MONA OFFSHORE WIND PROJECT

Schedule of Changes to the Change Request: draft Development Consent Order

Application Reference: EN010137

Document Reference: S_CR_12

**Drawing Title:**  
LAND PLAN - ONSHORE  
SHEET NUMBER: 11

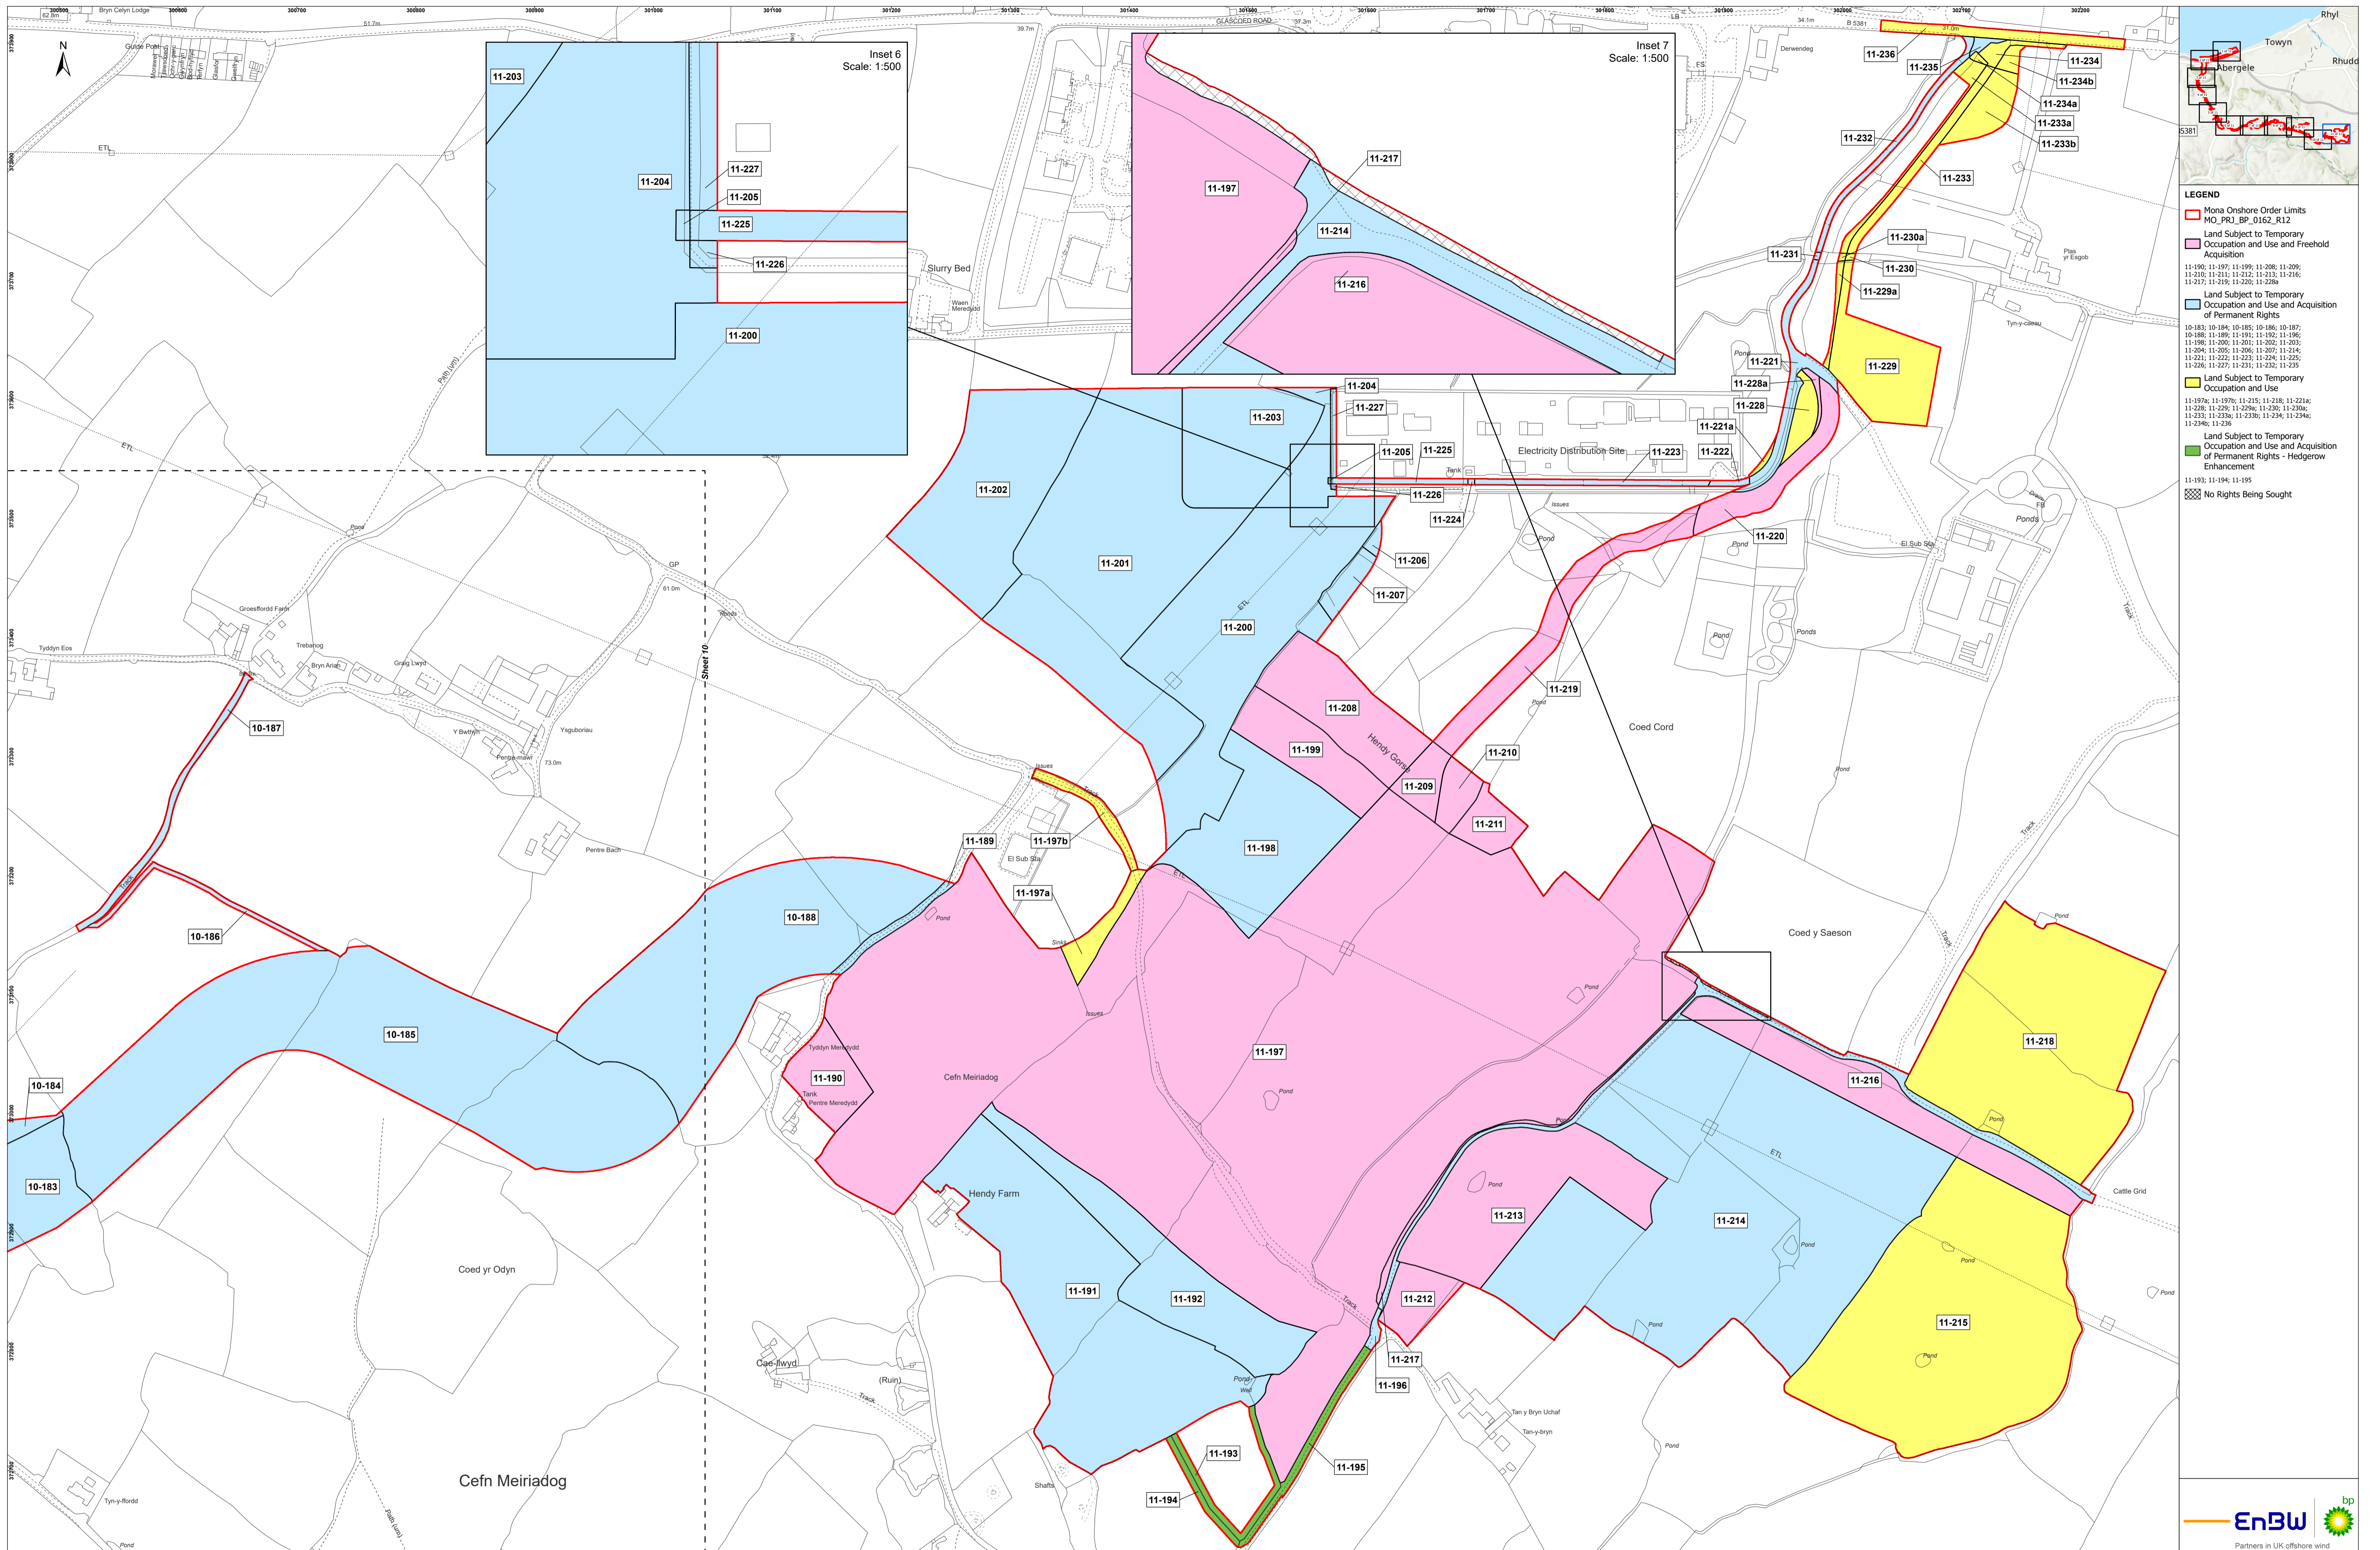
Schedule 7, Table titled 'In the County of Denbighshire:' row 4

A new row has been inserted as follows:

<i>11-197b</i>	<i>Onshore site preparation works</i>	<i>Work No. 27</i>
----------------	---------------------------------------	--------------------

To move 11-197b into its own row to clarify that it will be for onshore site preparation works only (as explained in the Applicant's Response to ExA letter dated 8 November - CR1-014).

Drawing Title:
STREET WORKS AND ACCESS TO WORKS PLANS - SHEET 11

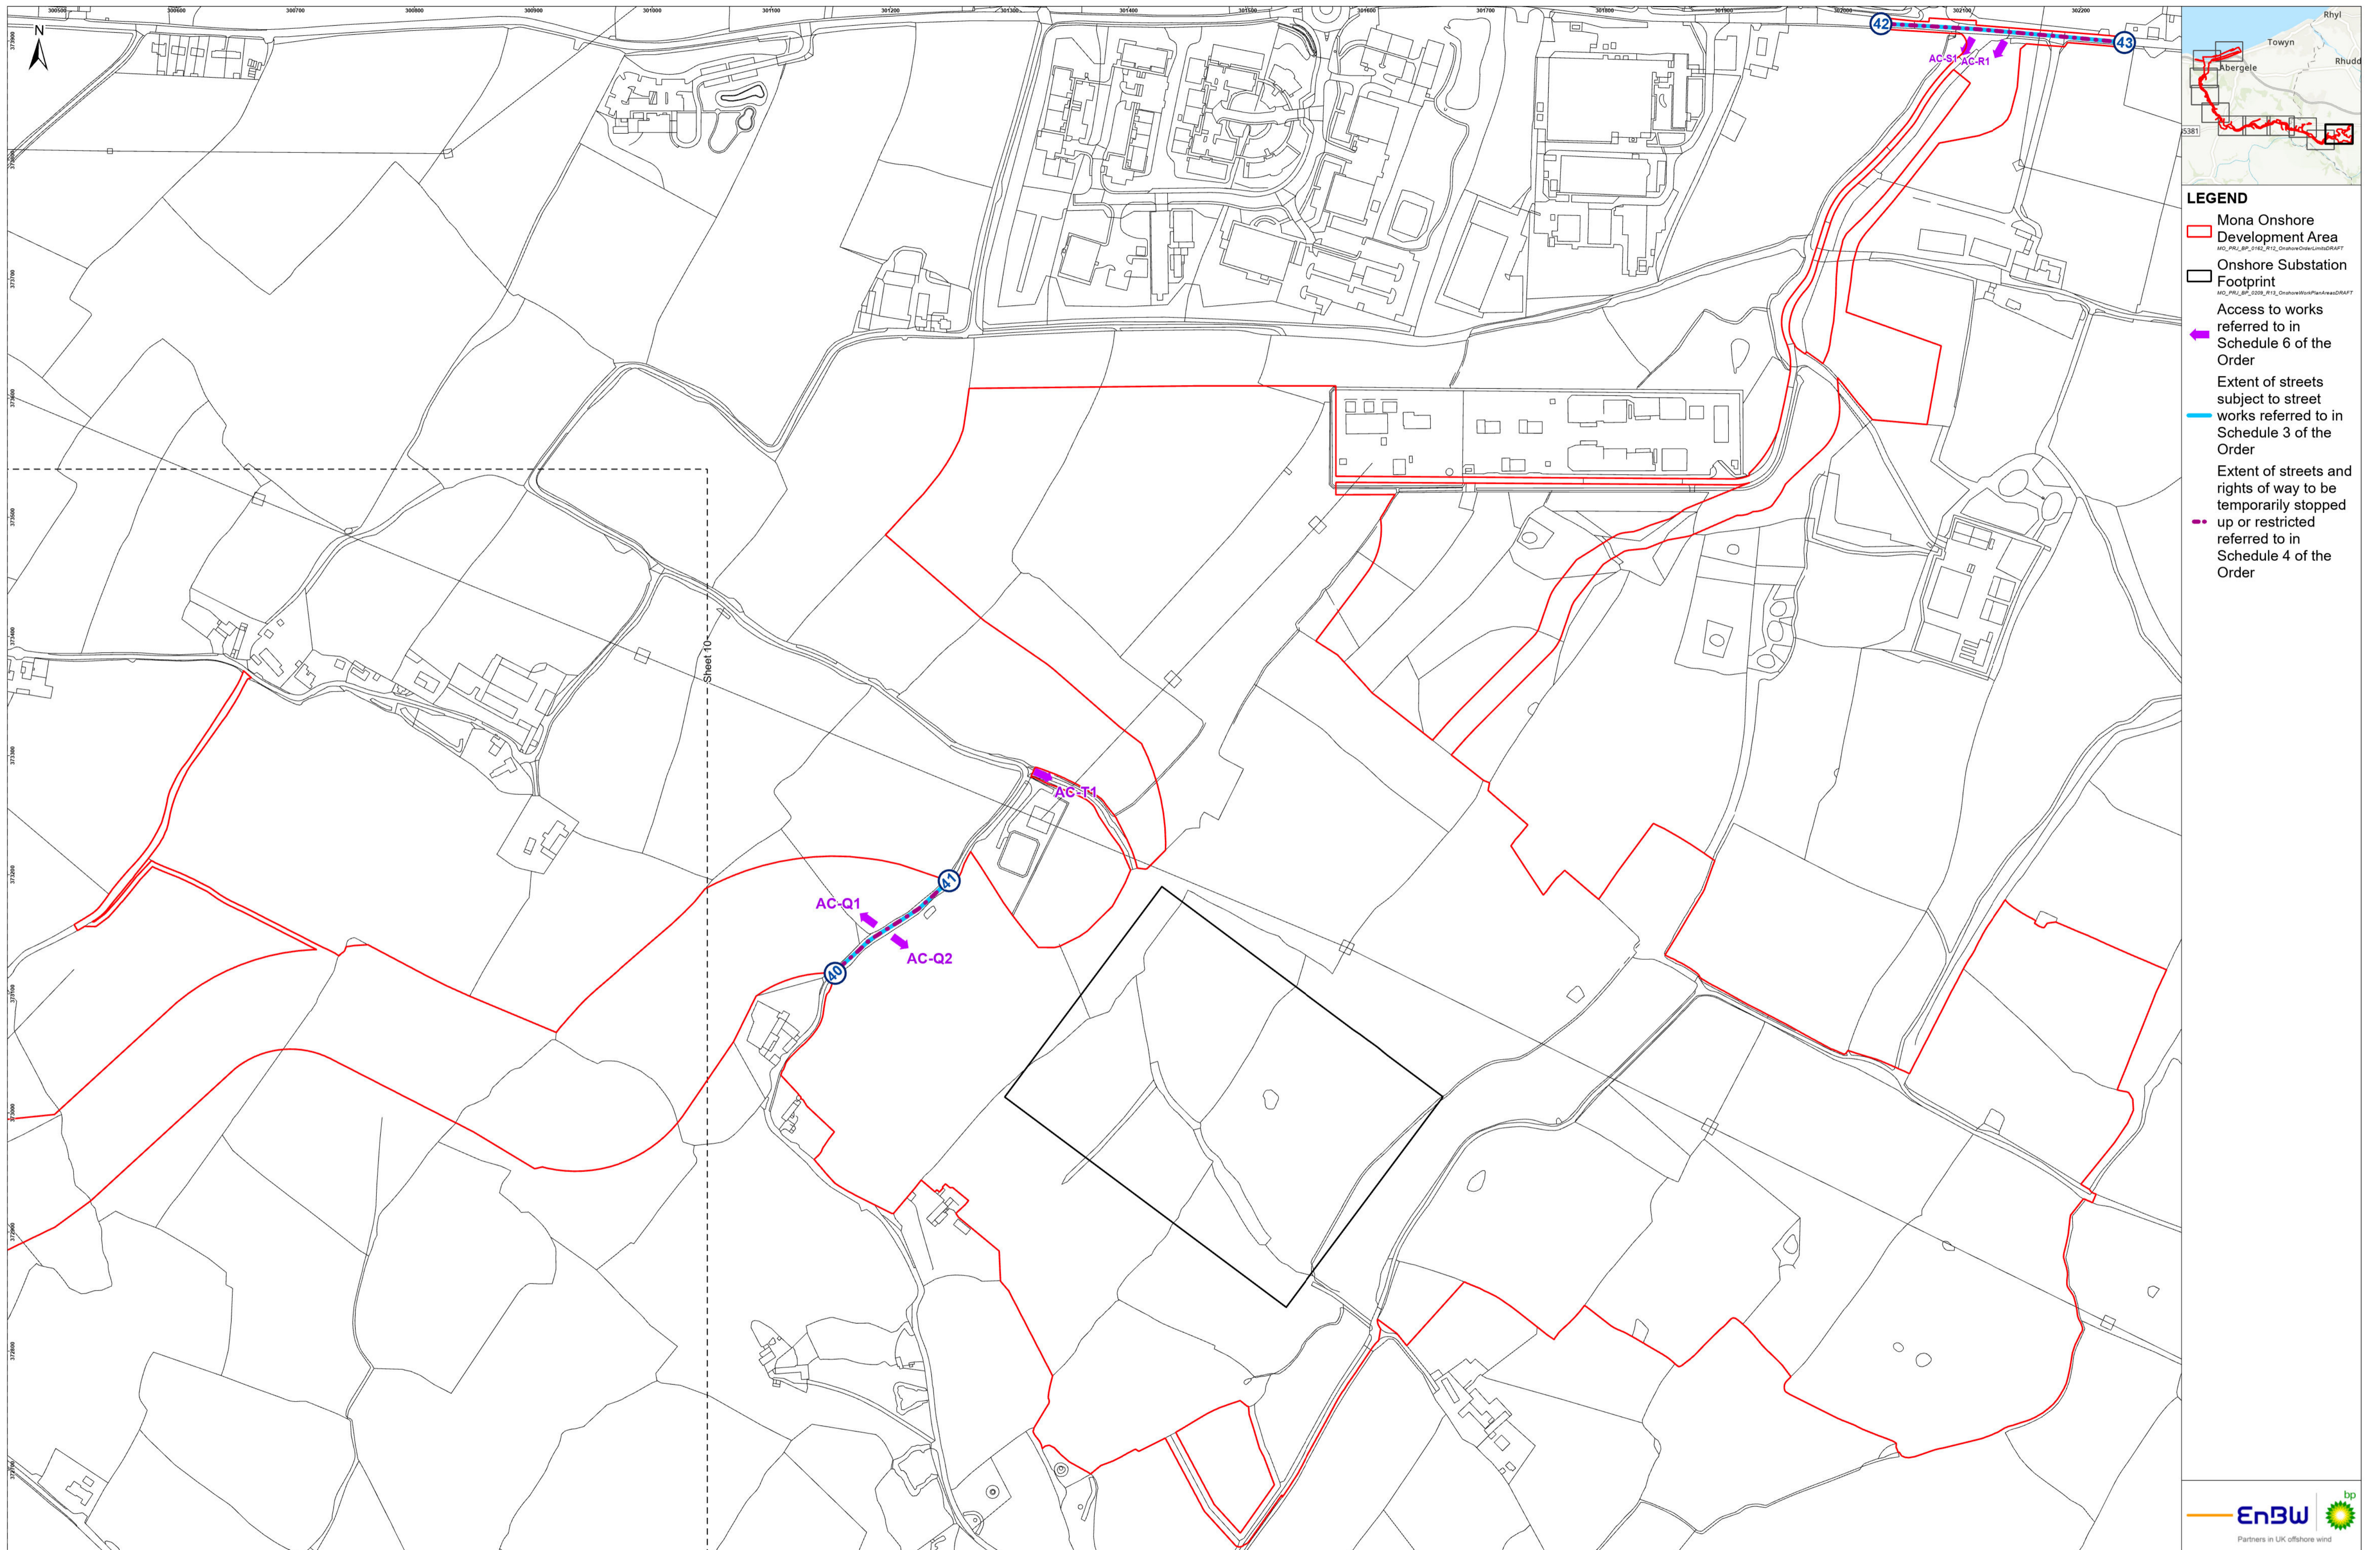
Article/Paragraph/Schedule Number	Amendment	Reason		
<p>Schedule 6</p>	<p>A row has been inserted at the end of the table as follows:</p> <table border="1" data-bbox="613 459 1570 528"> <tr> <td data-bbox="613 459 730 528"><i>AC-T1</i></td> <td data-bbox="730 459 1570 528"><i>From public highway unclassified road as shown on sheet 11 of the street works and access to works plan</i></td> </tr> </table>	<i>AC-T1</i>	<i>From public highway unclassified road as shown on sheet 11 of the street works and access to works plan</i>	<p>This amendment is required to effect the changes detailed in the Change Request Report (Document Reference S_CR_2 F02).</p> <p>Whilst there is an updated Street Works and Access Plan provided with this Change Request (Document Reference S_CR_6 F02) to illustrate this change, the draft development consent order has not been drafted with reference to that document. Instead the original definition of street works and access to works plan is retained on the basis that should the Change Request be accepted, that street works and access plan will be updated with the additional access.</p>
<i>AC-T1</i>	<i>From public highway unclassified road as shown on sheet 11 of the street works and access to works plan</i>			
<p>Schedule 7, Table titled ‘In the County of Denbighshire:’, row 3, column 1</p>	<p>The following amendments have been made:</p> <p><i>11-197a, 11-223b, 11-228, 11-229a, 11-230, 11-230a, 11-233, 11-233a, 11-234, 11-234a, 11-234b, 11-236</i></p>	<p>These additional plots in relation to the power to take temporary possession are required to effect changes 1-3, as detailed in the Change Request Report (Document Reference S_CR_2 F02).</p>
